REFERENCE	DE-2026/21
Date	30 March 2026

EXHIBITION OF STATE SIGNIFICANT DEVELOPMENT APPLICATION
CORRIMAL COKE WORKS – STAGE 2-4 EARLY STAGE (CIVIL WORKS)

Development	State Significant Development - Corrimal Coke Works – Stage 2-4 Early Stage (Civil Works) (SSD-86131212) - Request to Provide Advice on the Environmental Impact Statement (EIS)
Location	Lot 103 DP 1301632 Lots 3, 4 and 8 DP 1313981 Corrimal Cokeworks, Railway Street CORRIMAL NSW 2518

CORRIMAL COKE WORKS
STAGE 2-4 RESIDENTIAL SUBDIVISION
STORMWATER
LAYOUT PLAN

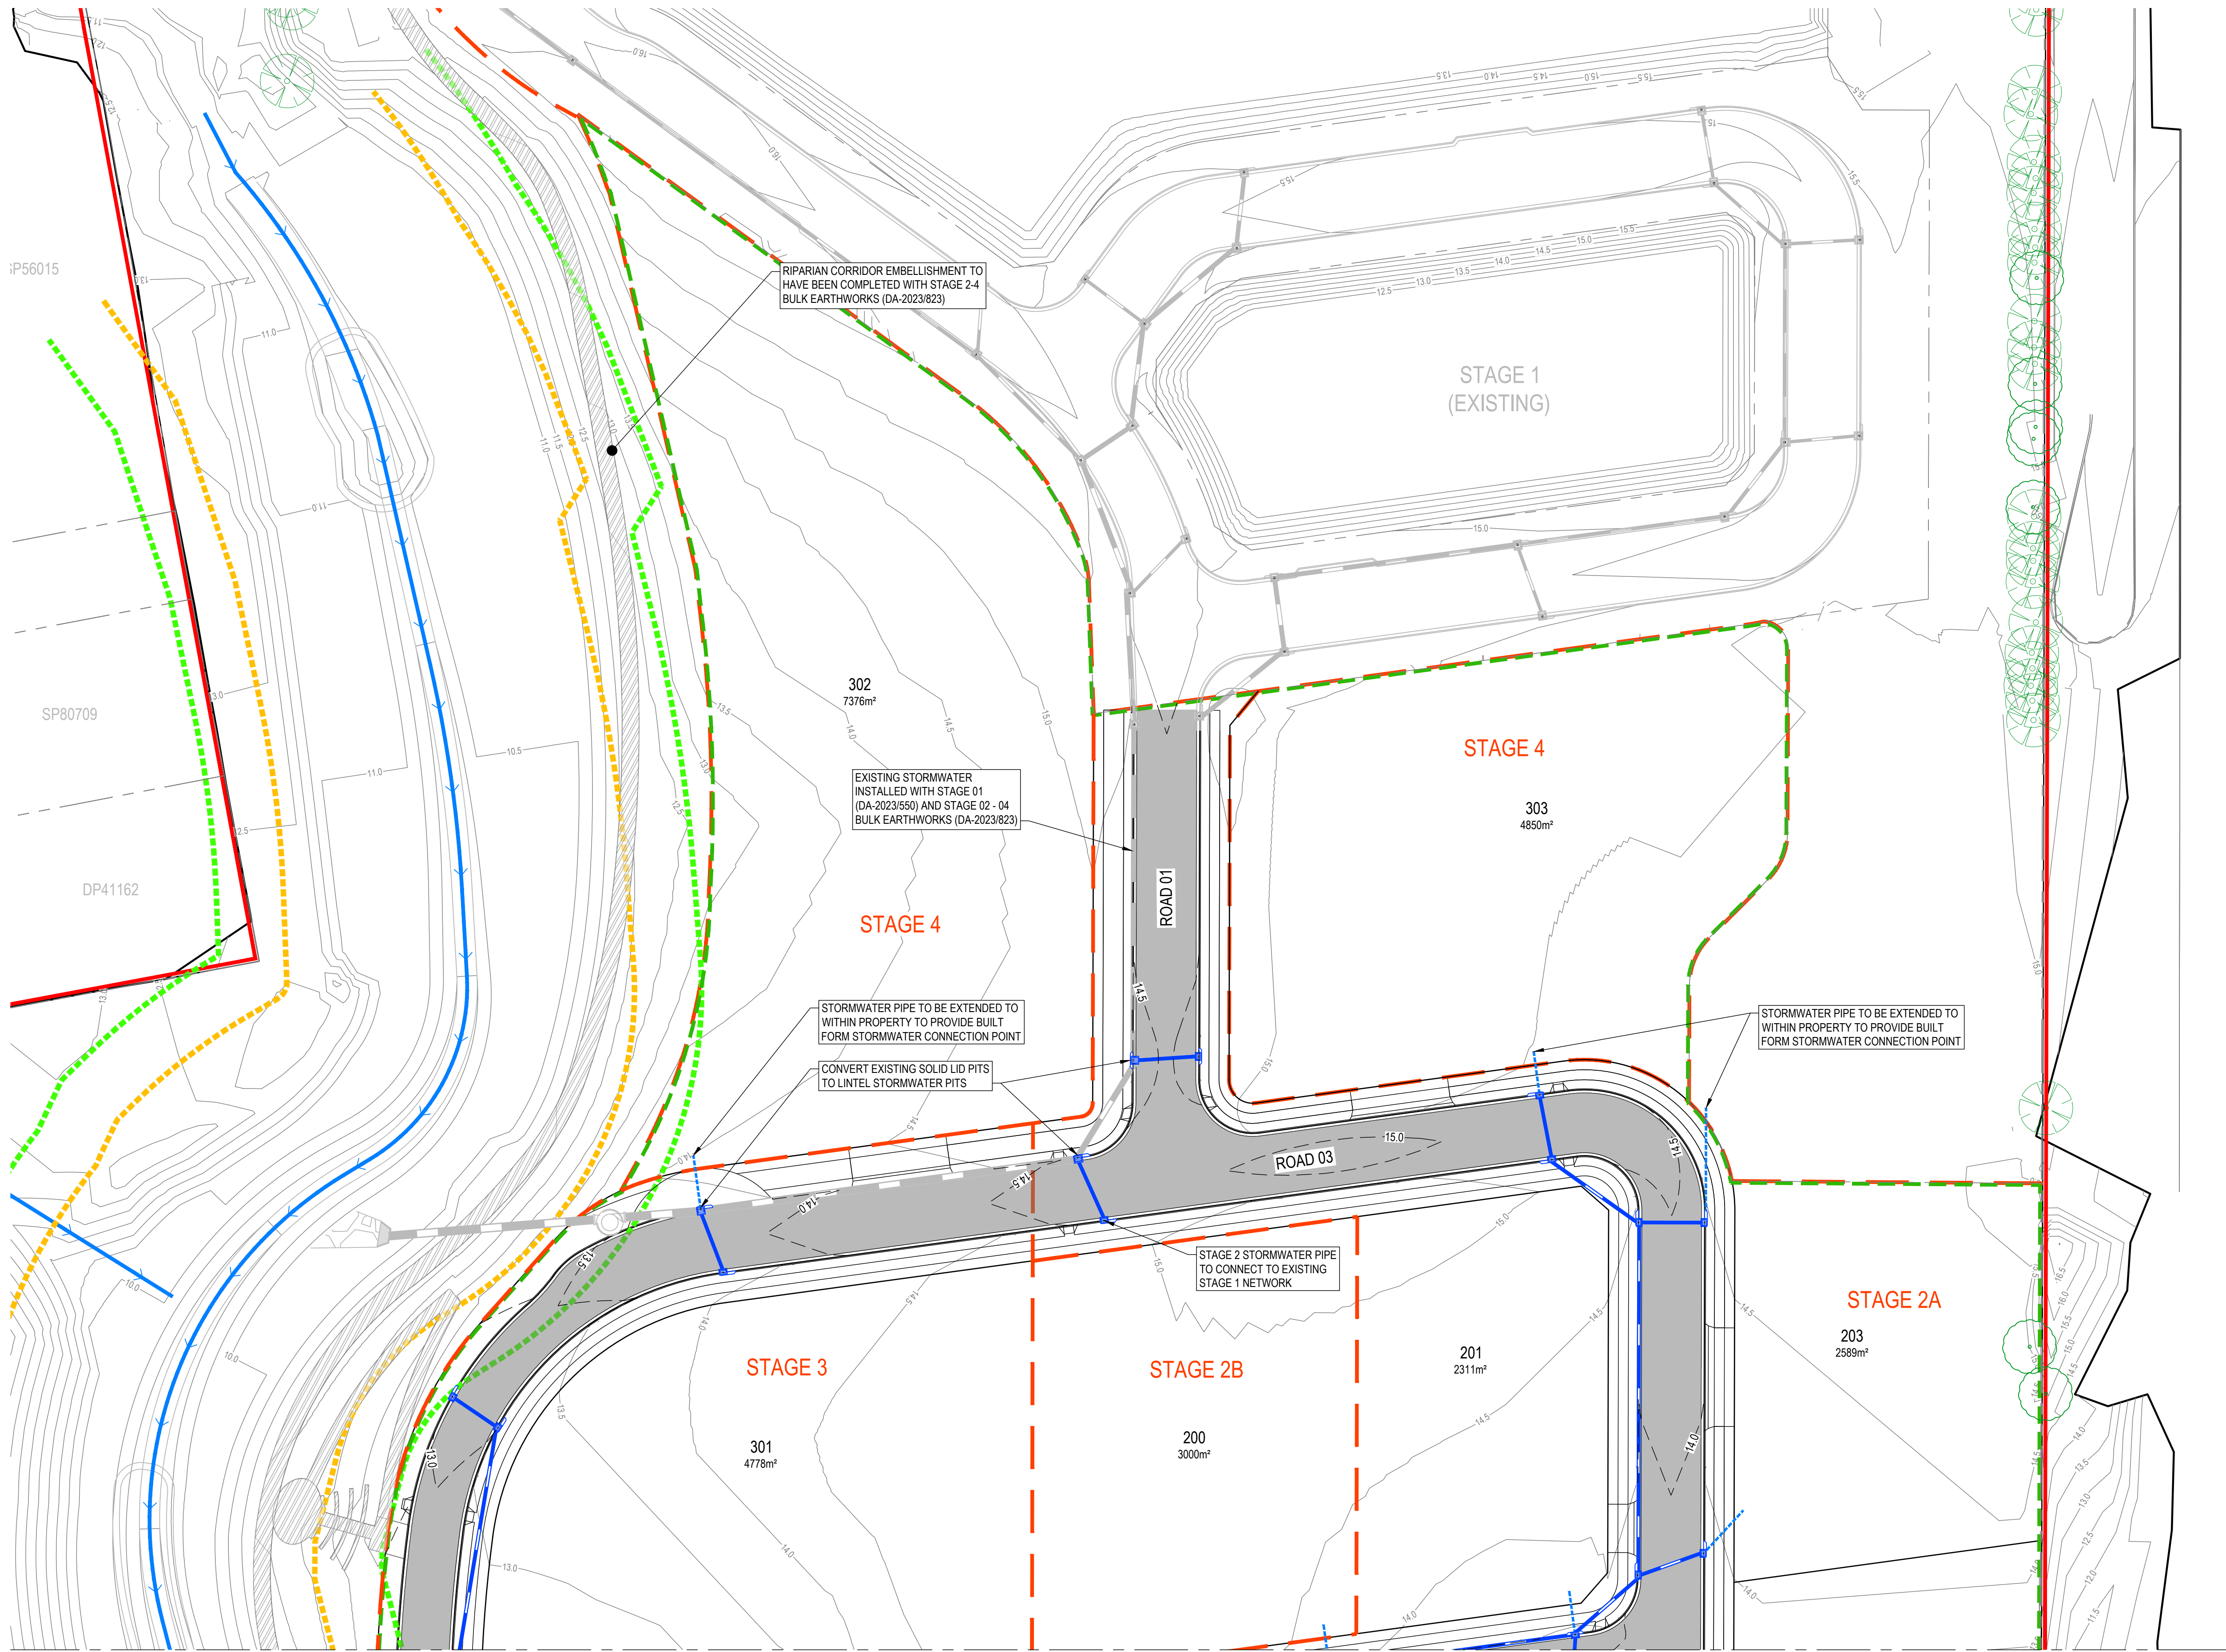
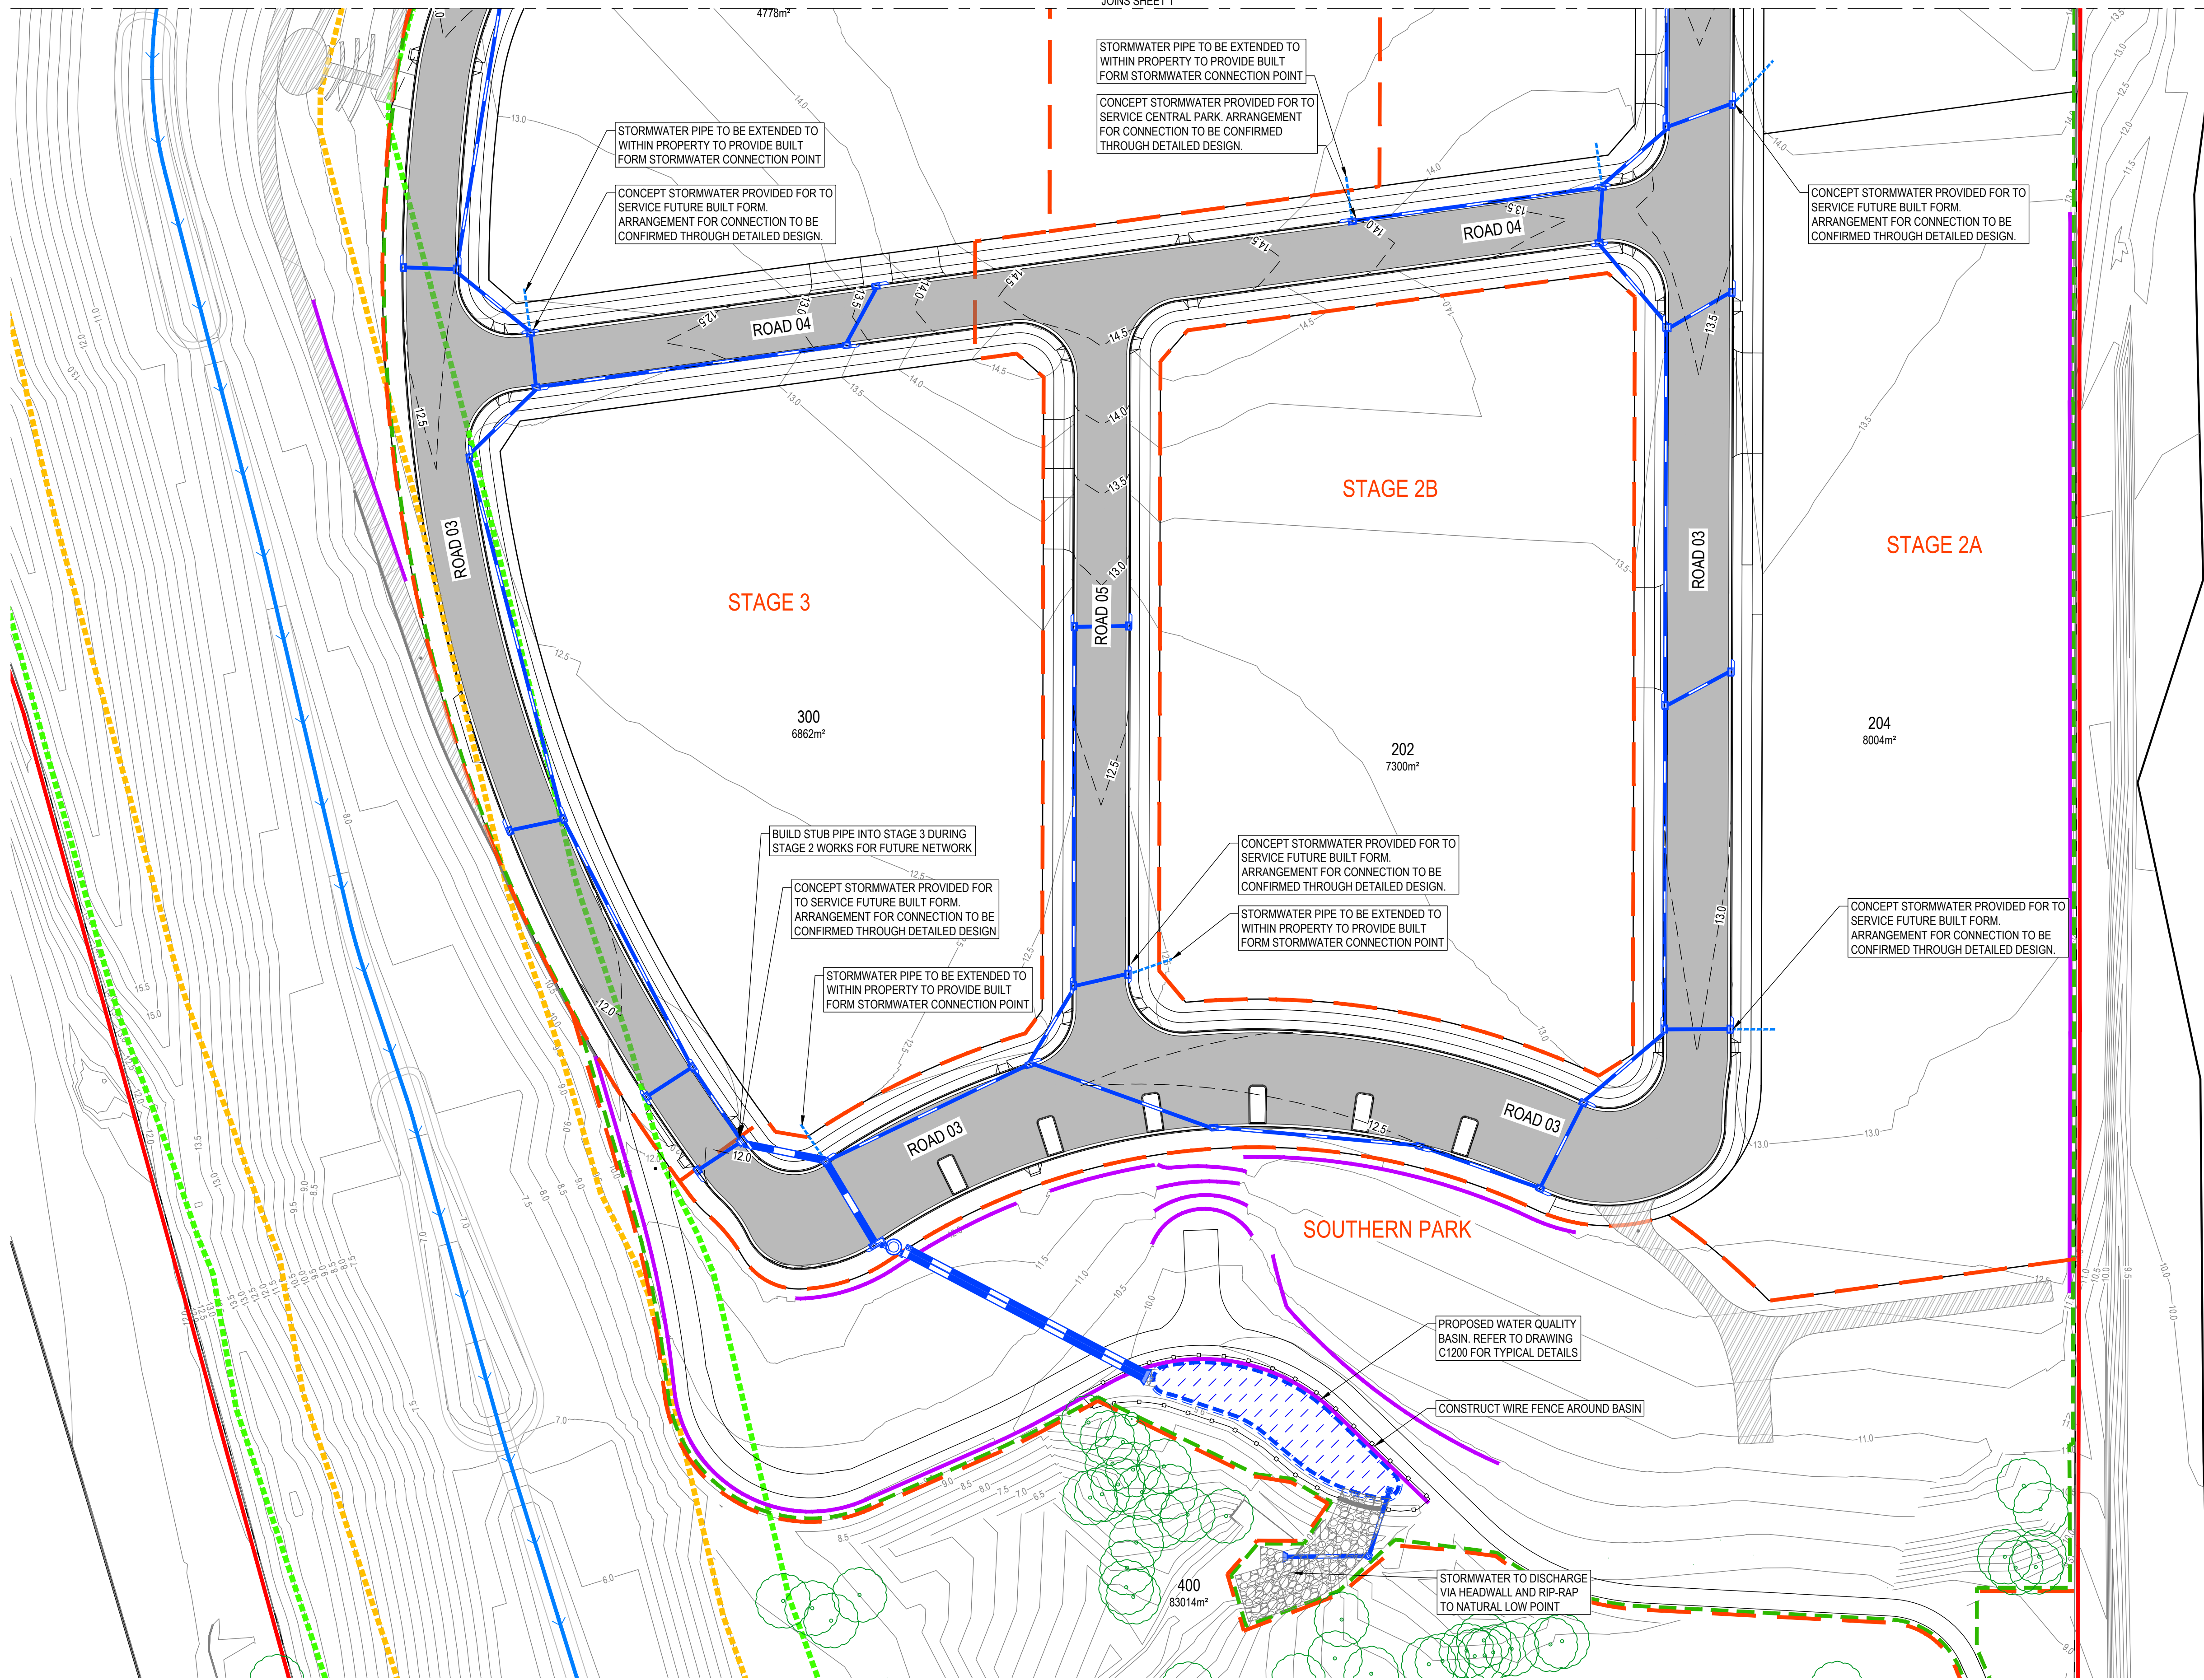
- Multiple proposed street-tree locations conflict with stormwater pits, pipes, service routes and underground infrastructure. The landscape plan must be amended to ensure all proposed trees are located clear of stormwater assets and underground services.
- Tree locations must be coordinated with the civil engineering plans to avoid structural conflicts, asset damage and future maintenance constraints.
